From: Martin Hill <Martin.Hill@arun.gov.uk>
Sent: 03 February 2022 14:49
To: Planning.Responses <Planning.Responses@arun.gov.uk>
Subject: RE: Planning Consultation on: BR/285/21/PL

Comments from Private Sector Housing:

Application No: **BR/285/21/PL**

Site Address: Rear of 73-75 Aldwick Road Bognor Regis PO21 2NW

Component: Proposed First Floor Plan

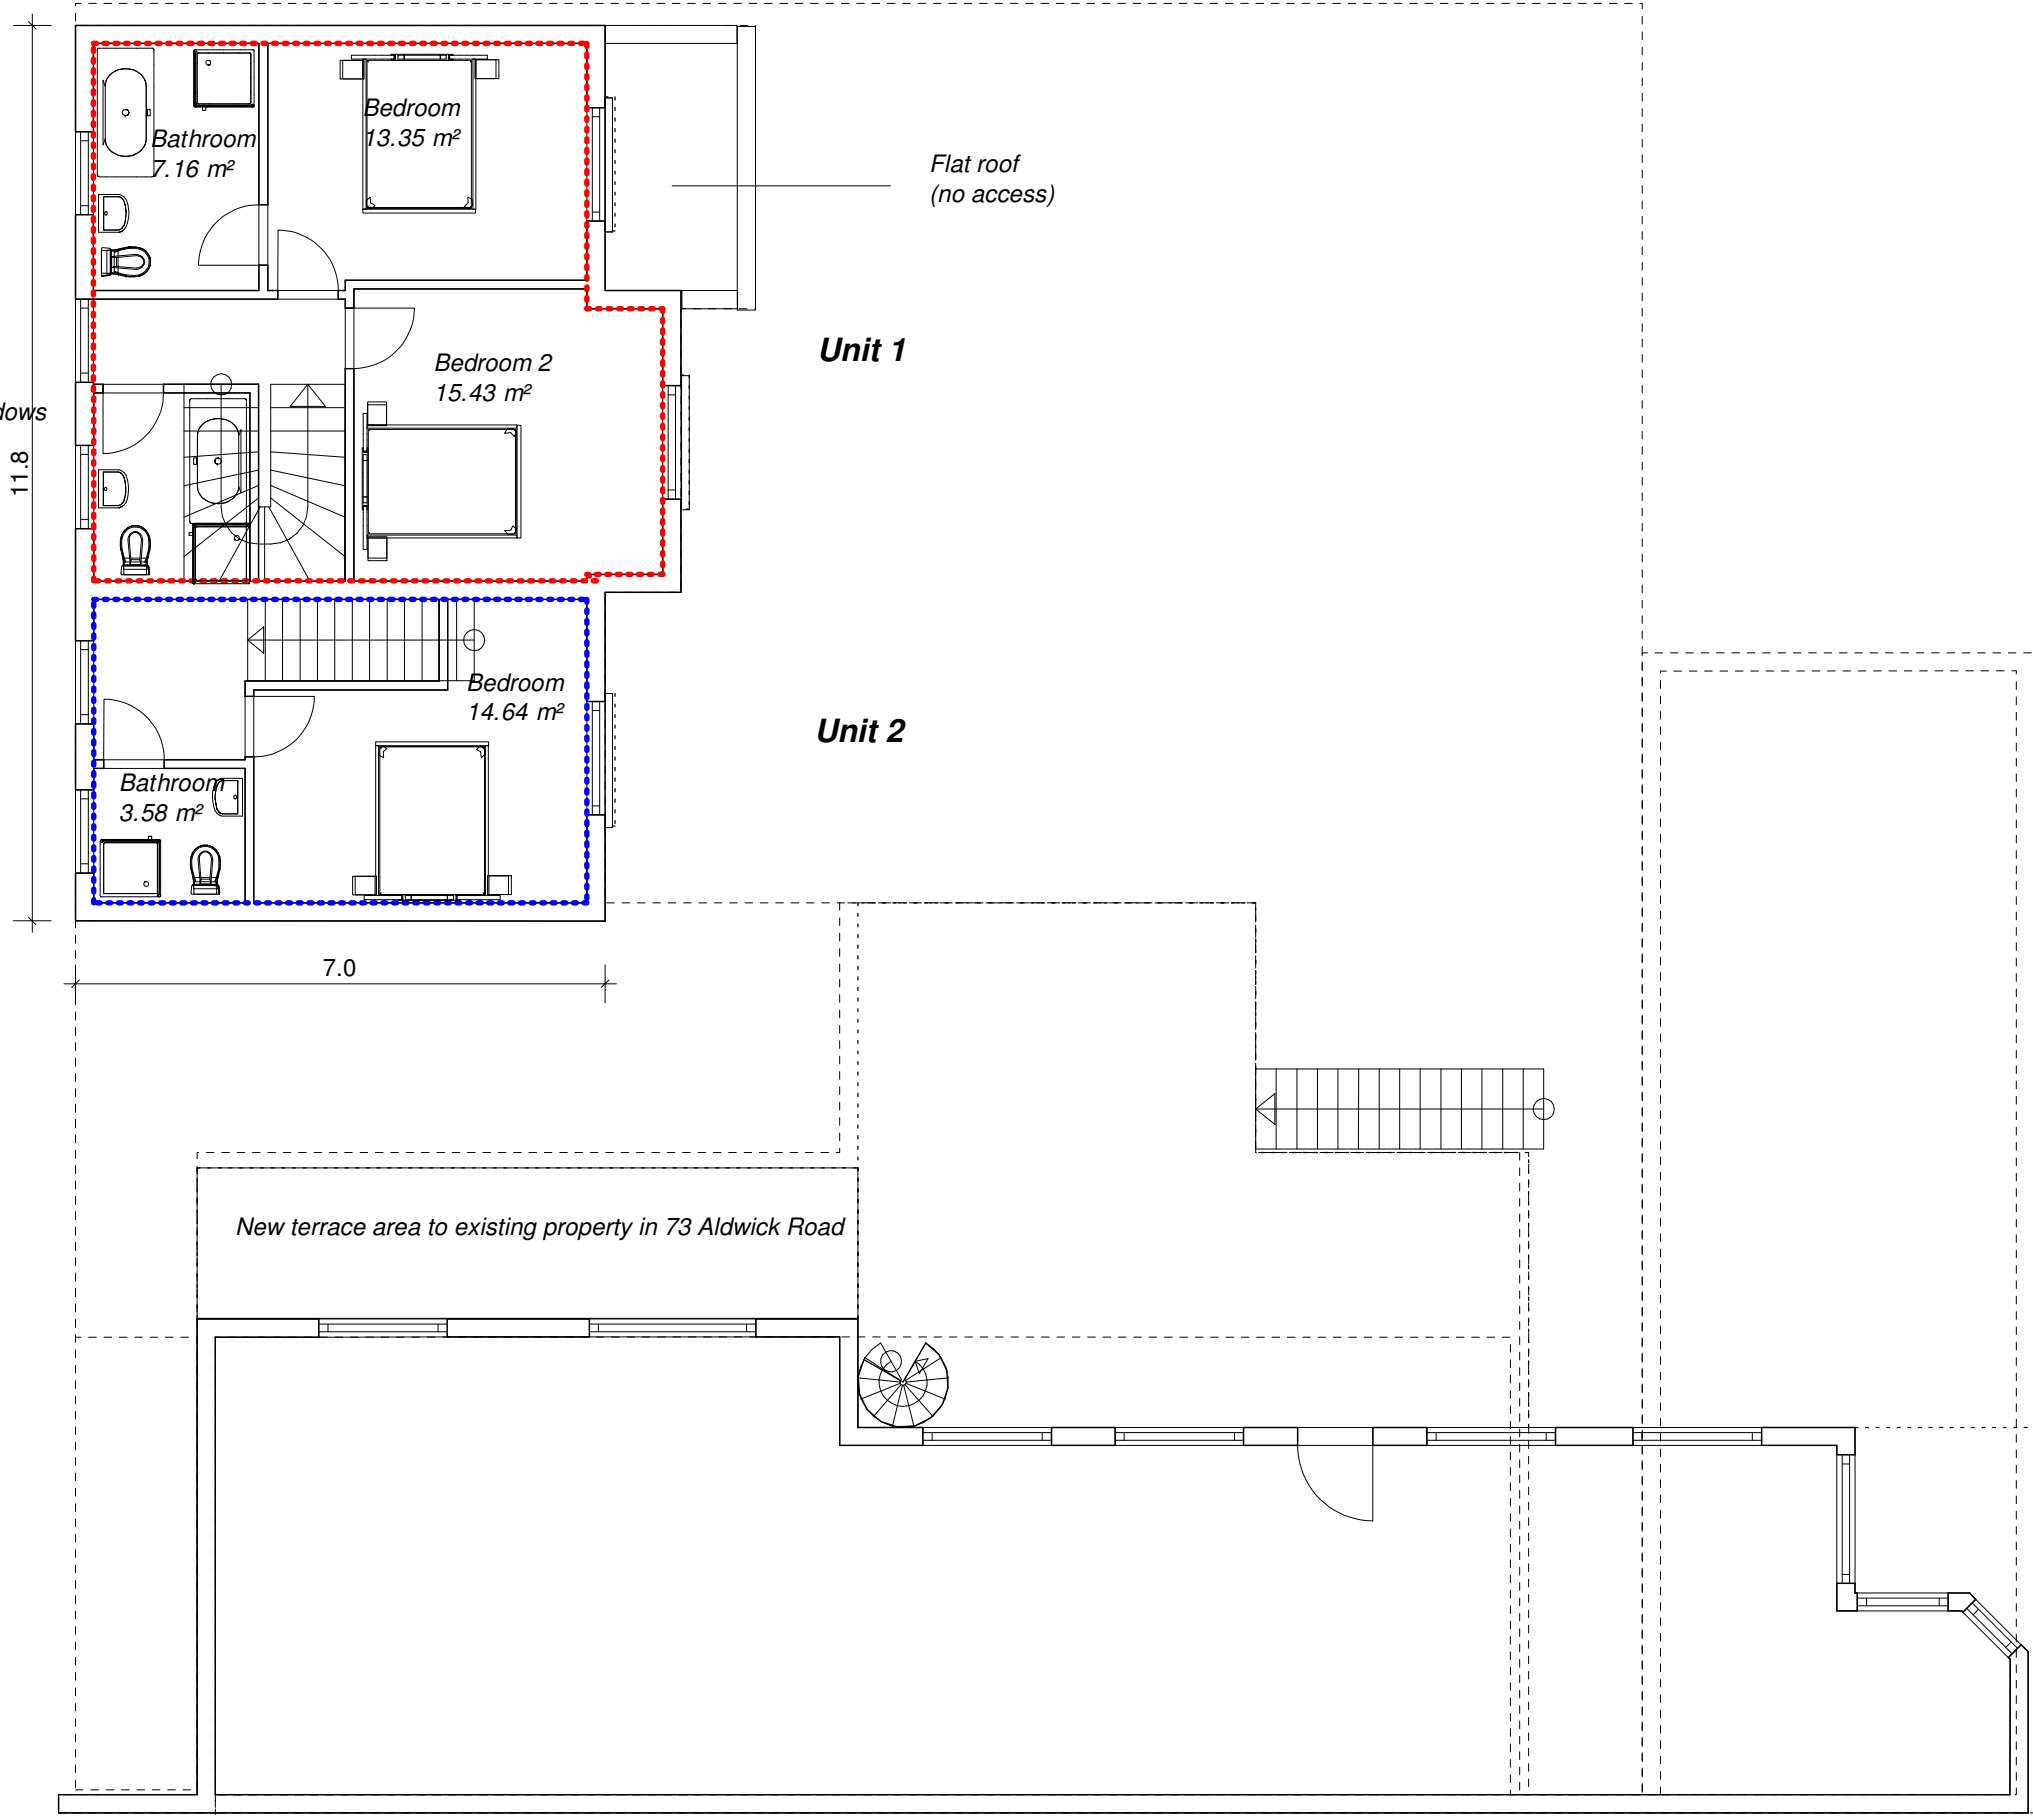
From the Design, Access and Planning Statement, it is understood from the application that Units 1 & 2 are not intended to be used as family occupation and that those units comprise one and two bedroom units. The floor plans provided, however, show Unit 1 being a three bedroom unit (1 bedroom illustrated on the ground floor) and Unit 2 has one bedroom and, unusually for a non-family dwelling, a "home office" on the ground floor. Comments made below are based on the assumption that Units 1 & 2 are intended to be Houses in Multiple Occupation (HMO) and Unit 3 a single household dwelling.

Component: Proposed Site Plan - Ground Floor

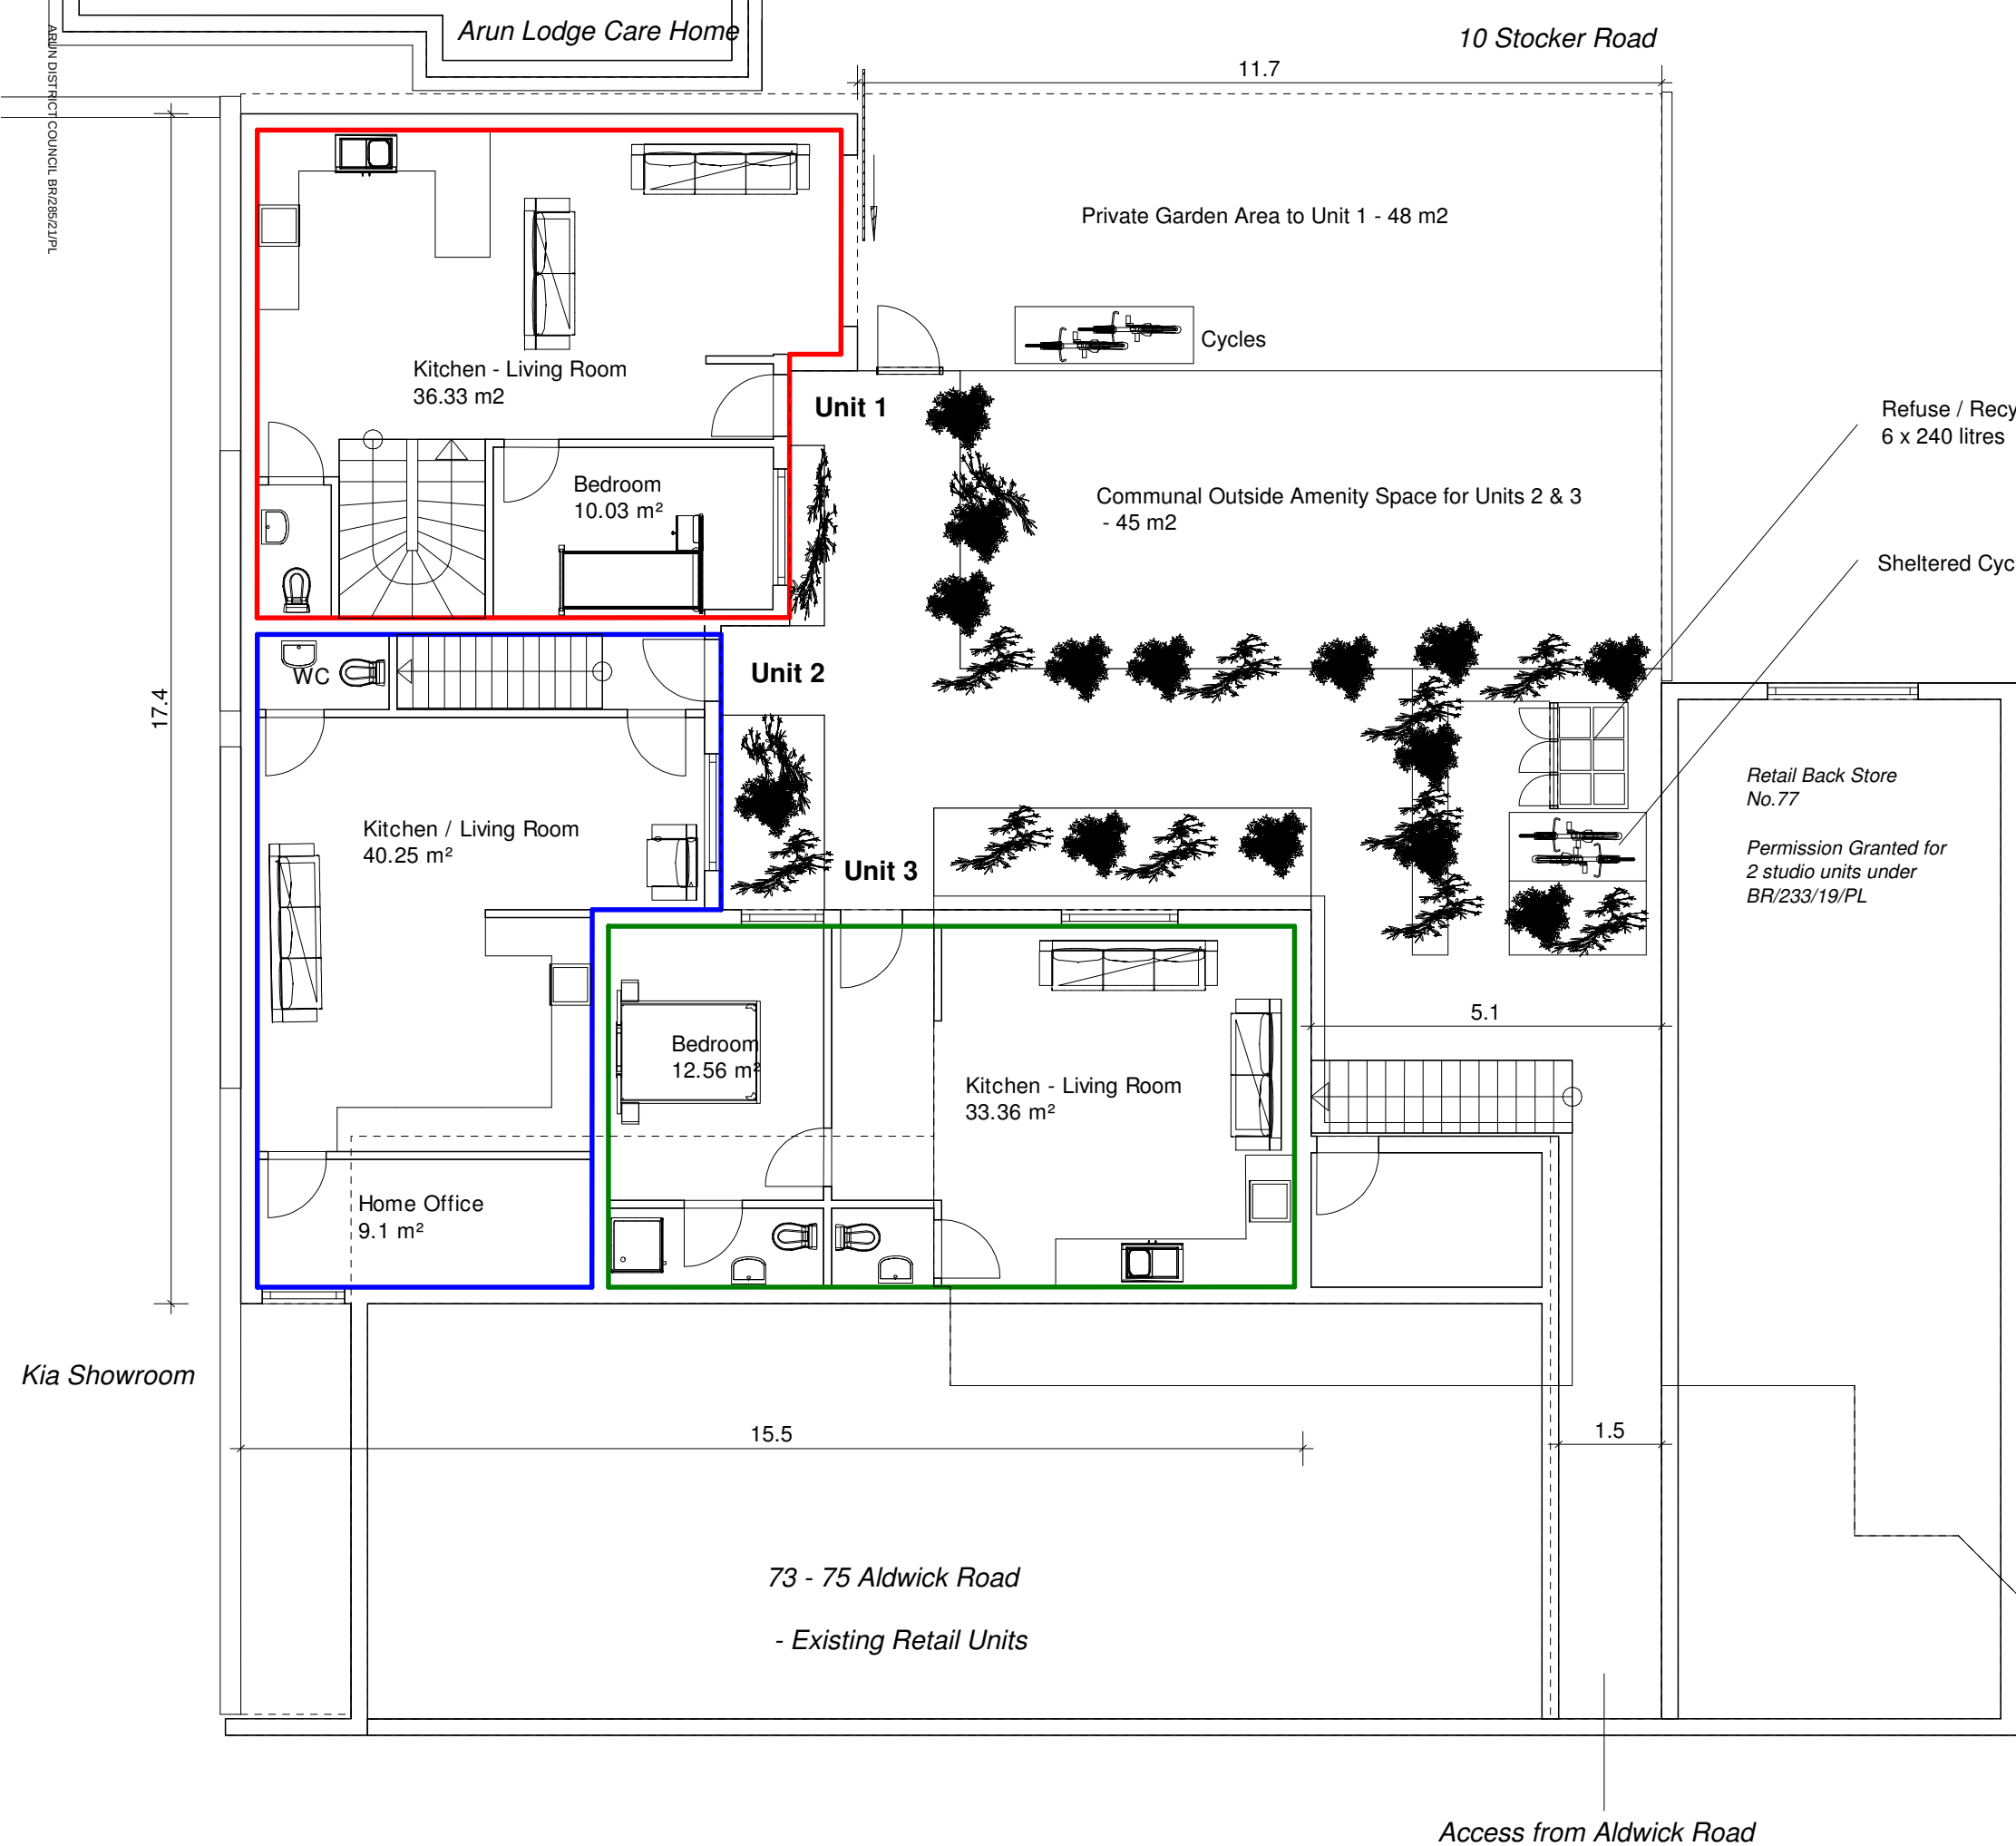
- A minimum 30 minutes fire resistance to be provided throughout the escape routes of Units 1 & 2.
- A room where the only escape route is through another room is termed an "inner room" and poses a risk to its occupiers if a fire starts unnoticed in the outer room. The escape routes from the bedrooms on the ground and first floor of Unit 1, the bedroom on the ground floor in unit 3 and the "Home Office" of Unit 2 are all via the kitchen and living room areas and are deemed inner rooms and the means of escape passes through high risk areas. This can be overcome as follows:

Unit 1: By creating a hallway on the ground floor and separating the kitchen from the other areas, with provision of an FD30S fire door to access the kitchen off the hallway. This overcomes the inner room situation and all rooms would open onto the hallway, which would be the means of escape.

Unit 2: Providing an emergency escape window from the "Home Office" room, installation of interlinked smoke detection in the vicinity of the access door (suitably located away from cooking appliances and reconfiguration of cooking appliances may be required) and provision of an FD30S fire door to the Home Office room. Please note that the escape route from any escape window must be unobstructed and provide a safe route away from the building, to a point of ultimate safety (e.g. not a courtyard or other enclosed area where escape would be restricted).*

Unit 3: By creating a hallway separating the kitchen from the bedroom, with provision of a close fitting conventional door (as a minimum) to access the kitchen off the hallway. This overcomes the inner room situation and all rooms would open onto the hallway, which would be the means of escape.

- There should be adequate fire separation between the commercial unit and the residential dwellings. It should also be carefully considered as to the nature of the commercial undertaking adjoining the property from a fire safety perspective, such as the use and storage of flammable substances in order to determine the correct level of fire resisting separation required.
